Project Name / File No.: Brodie / PA22-023  
Applicant: JM1 Holdings, LLC  
Project Description: 45 Lot PRD-Subdivision  
Re: Response to 1<sup>st</sup> Review Comments

This letter serves as the Applicant's formal response to the 1<sup>st</sup> review comments received on August 15<sup>th</sup>, 2022 to our recent application materials submitted to the City of Marysville. To ensure that each of the comments have been responded to, we have incorporated each of the City's comments along with the Applicant's response to each below.

**PP-01**  
 SHEET 2 OF 3

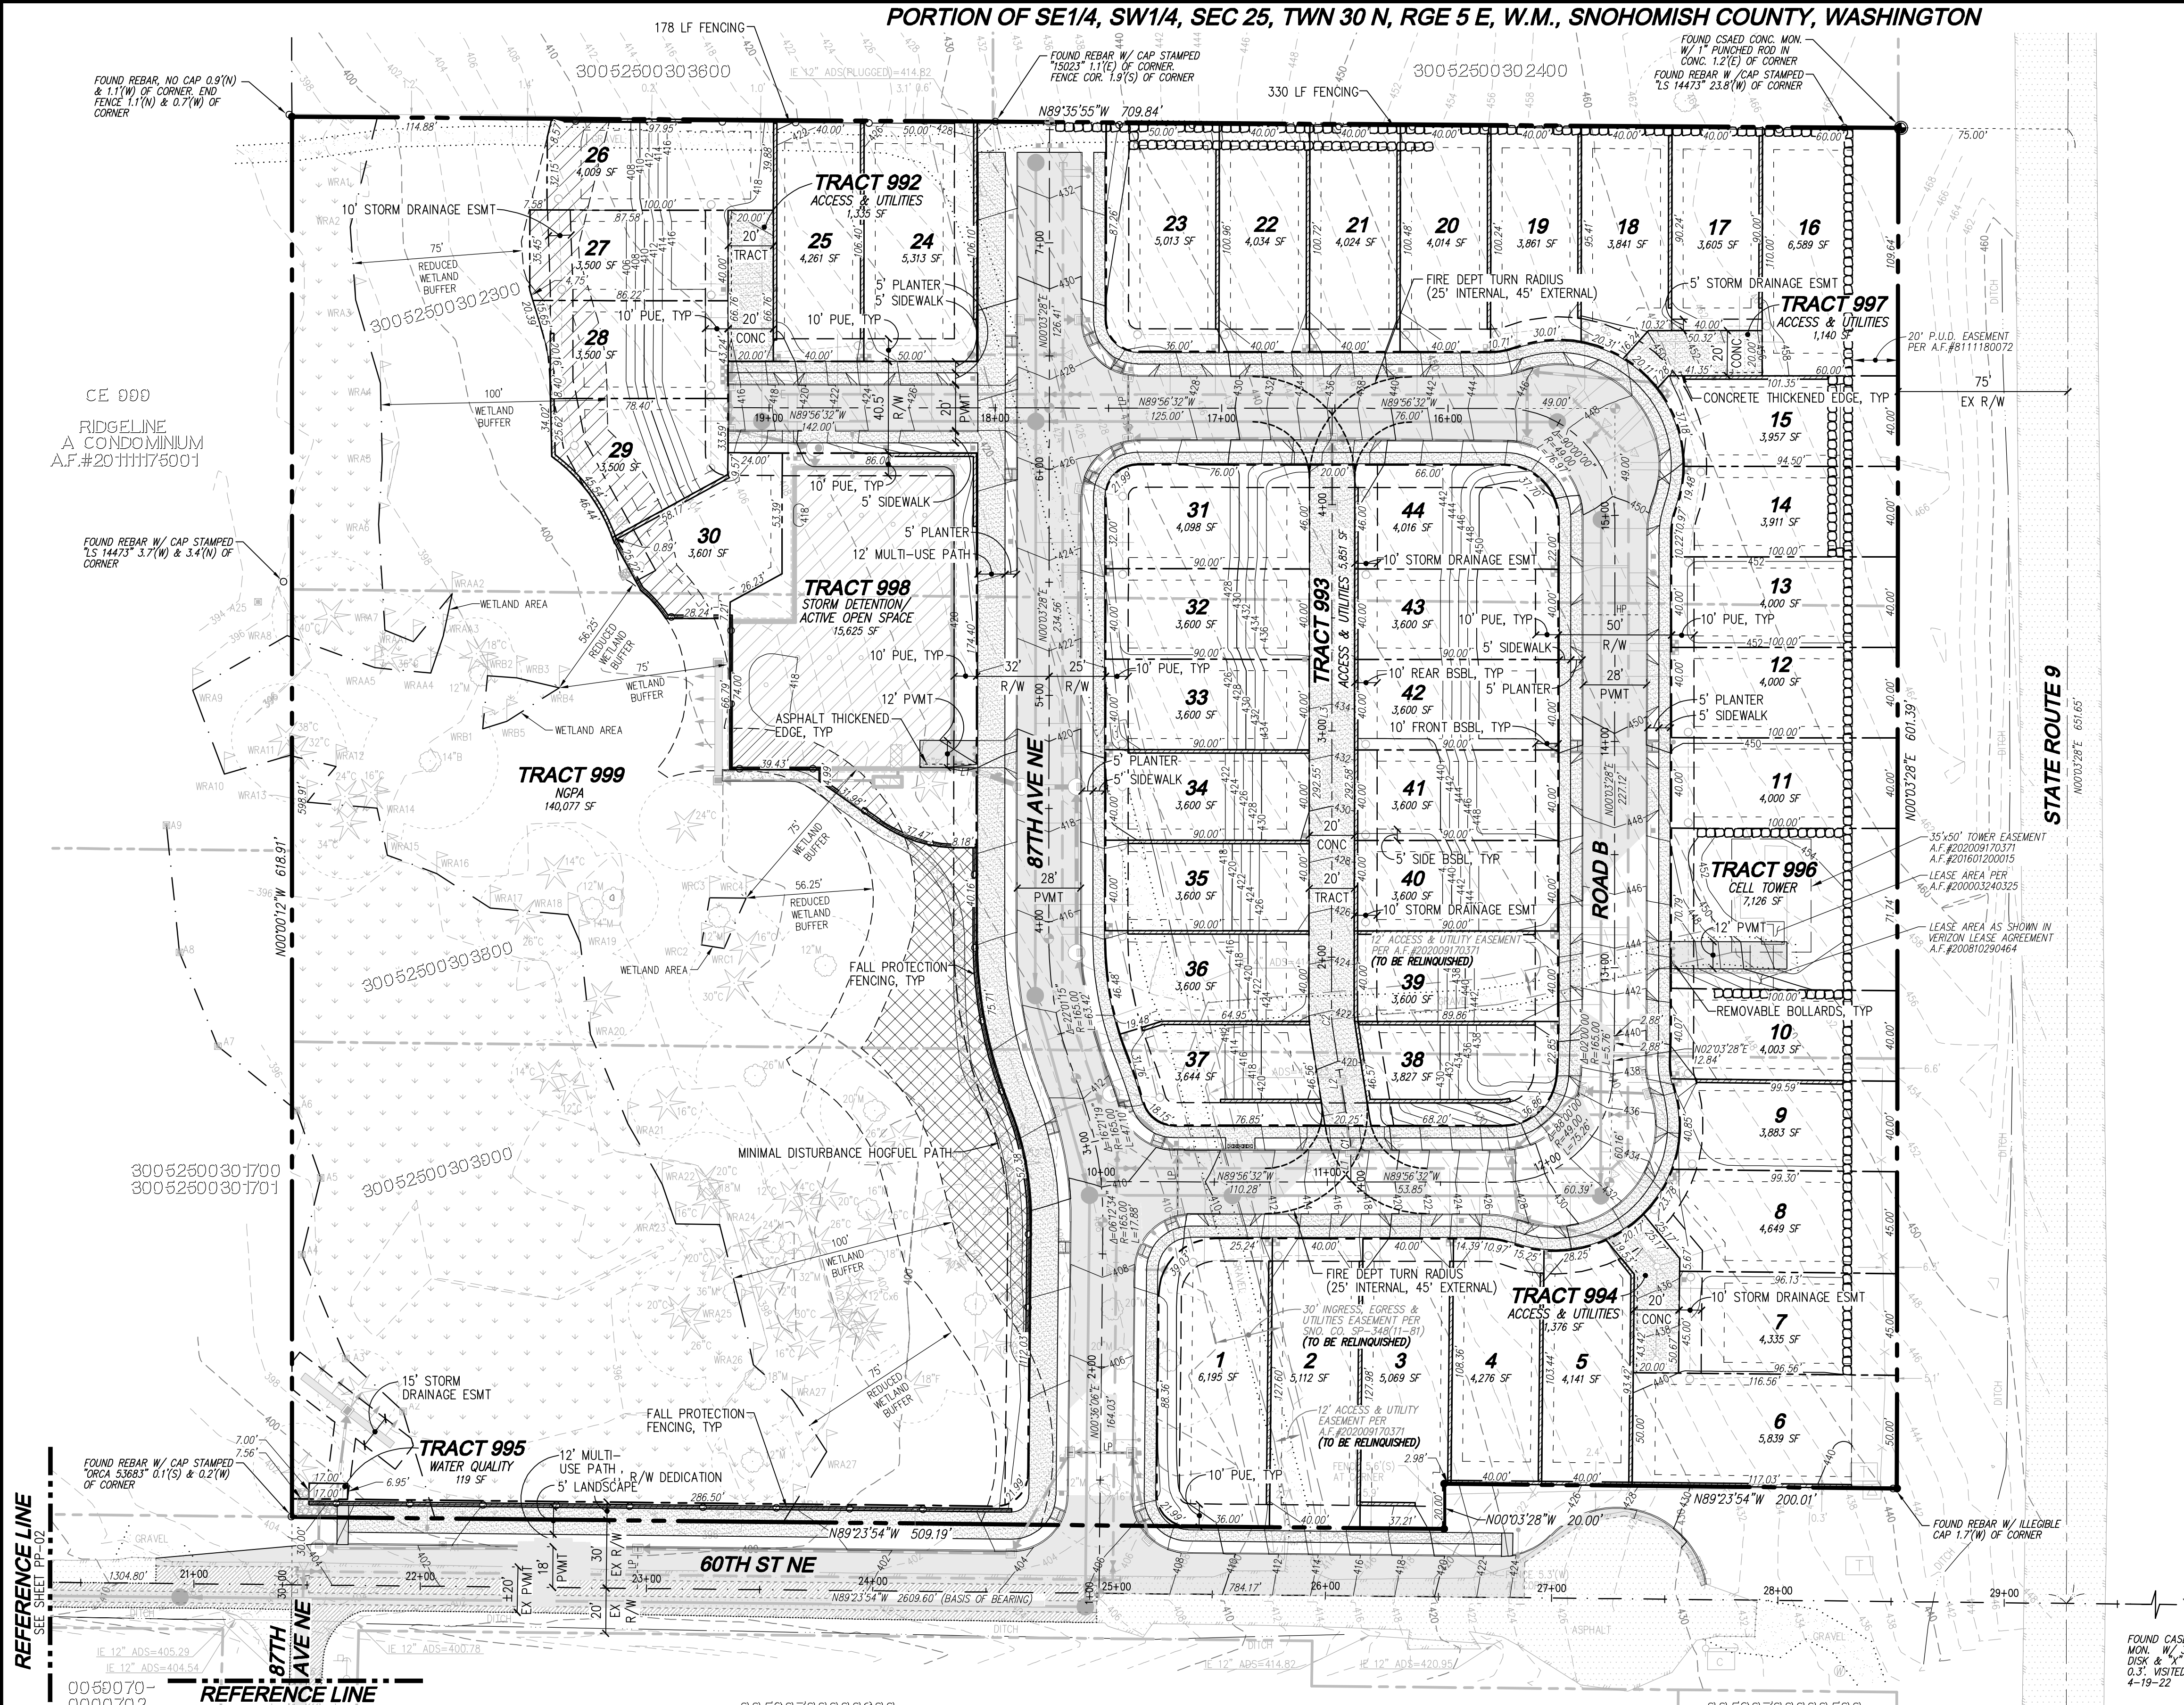
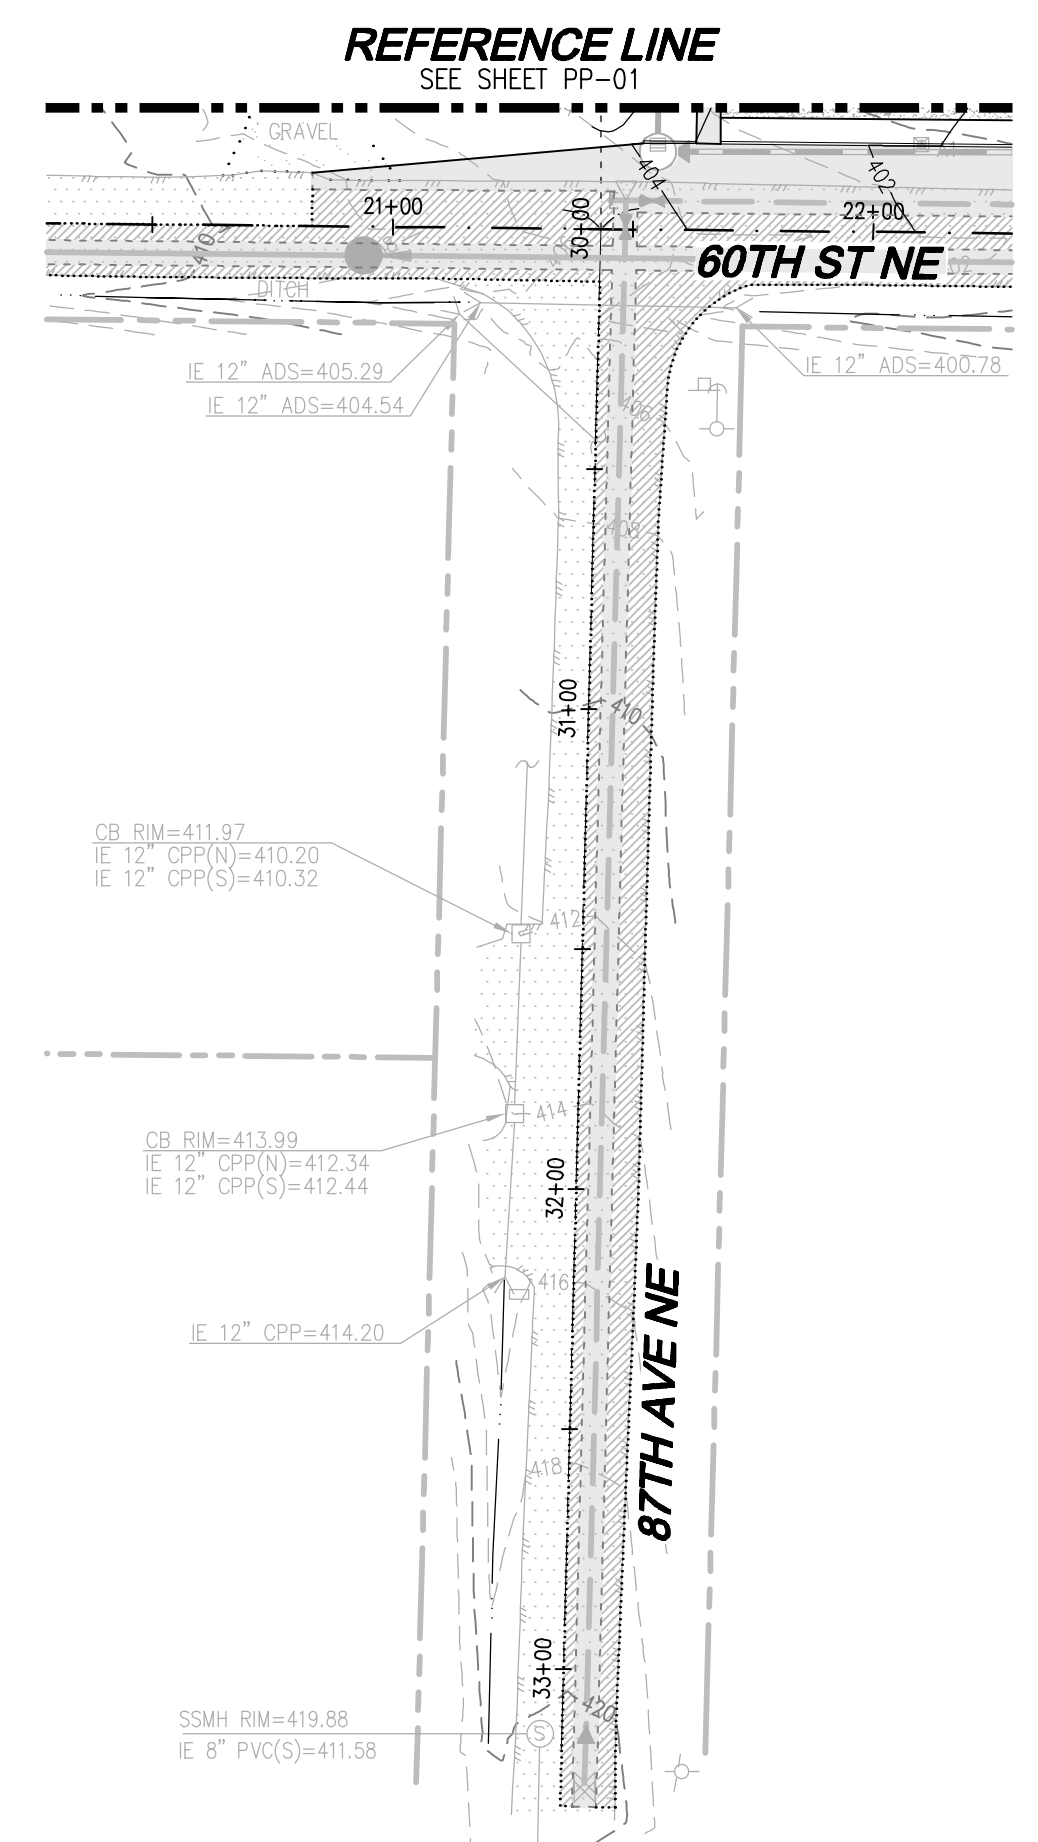
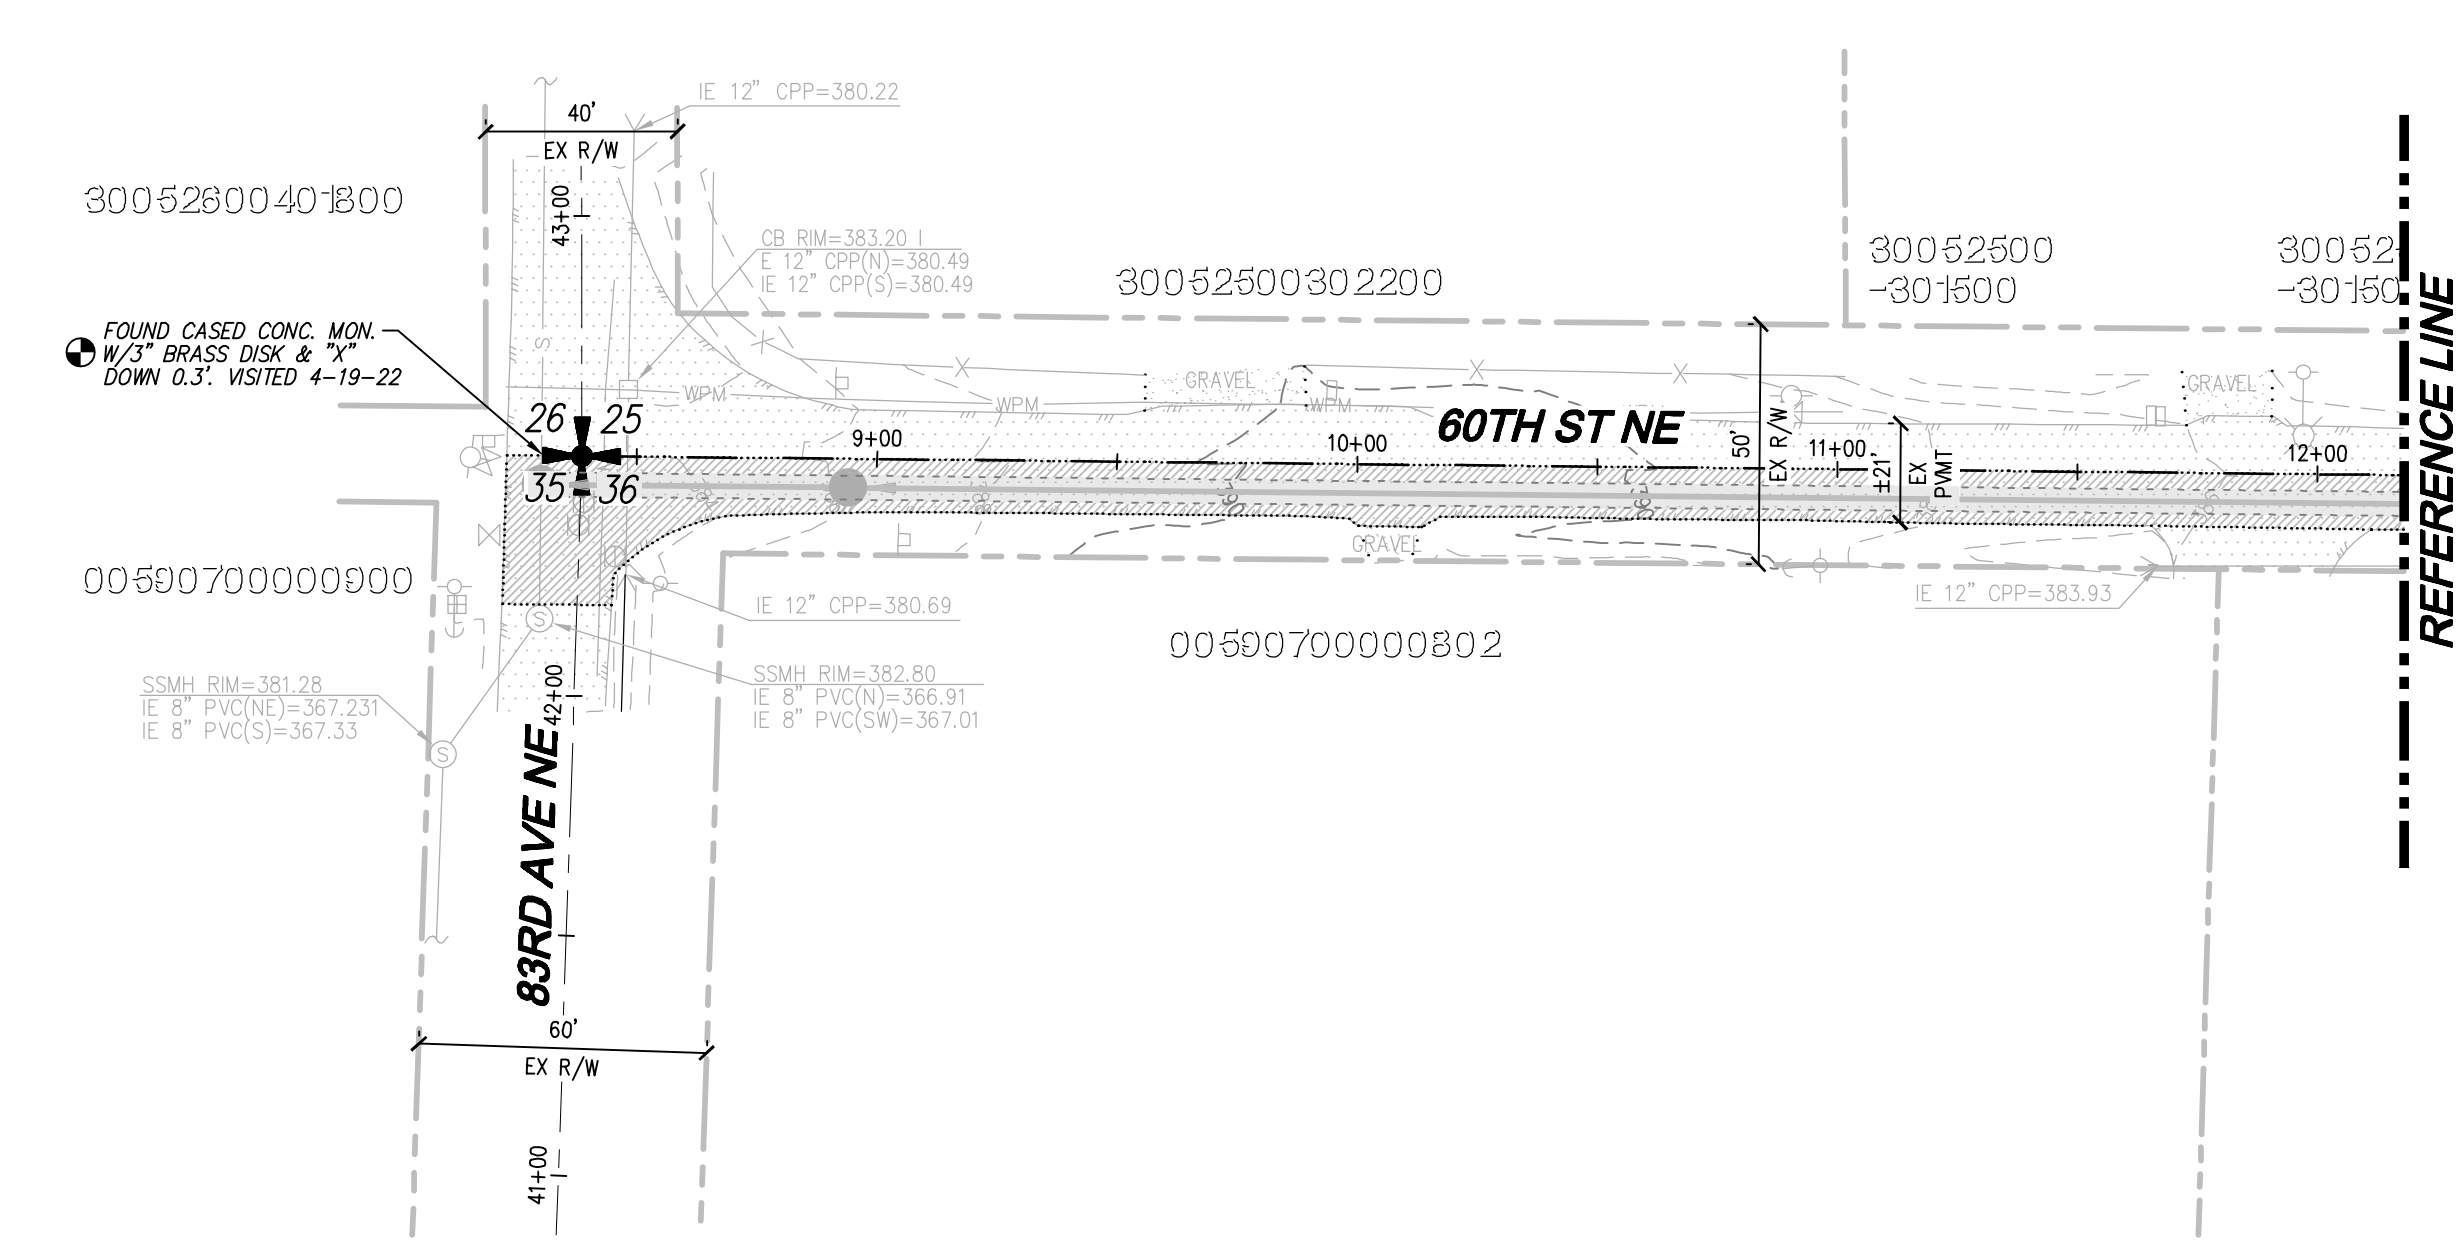
<u><b>WETLAND BUFFER AVERAGING CALCULATIONS</b></u>	
WETLAND BUFFER REDUCTION:	5,539 SF
WETLAND BUFFER ADDITION:	5,556 SF
NET:	17 SF

4. To aid in quick reference and review, provide a table within the site plan that includes details for Tracts 990 – 999, including tract size and proposed use.  
**Applicant's Response: A table has been placed on the preliminary plat map that provides tract designations, sizes and uses for reference.**

10. Tract 998 proposes to include a portion of the proposed wetland buffer addition. This 644 sq. ft. buffer addition area will need to be relocated outside of the tract and not north of the proposal vault. Suggest moving the vault further north and incorporating the required buffer addition, south of Tract 998. Critical areas and their buffers must be incorporated into separate tracts; revise plans to remove that area from Tract 998 and include this buffer addition into Tract 999.

11. The provided plans appear to include proposed landscaped areas into the active open space area calculation of Tract 998; revise calculations to exclude the proposed Tract 998 buffer landscaping from the dedicated active open space area.

**Applicant's Response: The buffer averaging calculations are shown on revised plans. They match the buffer averaging provided by the critical areas study.**

**Applicant's Response: The site plan has been revised such that the detention vault lies within Tract 998. All wetland buffer addition is located outside of Tract 998.**

**Applicant's Response: The site plan has been revised such that the wetland buffer area is outside of Tract 998 and the active open space area.**
12. As proposed, Tract 998 does not appear to meet the open space requirements of MMC 22G.080.100(4), specifically: *(f) be situated and designed to be observable by the public; and (g) be accessible and convenient to all residents within the development.*
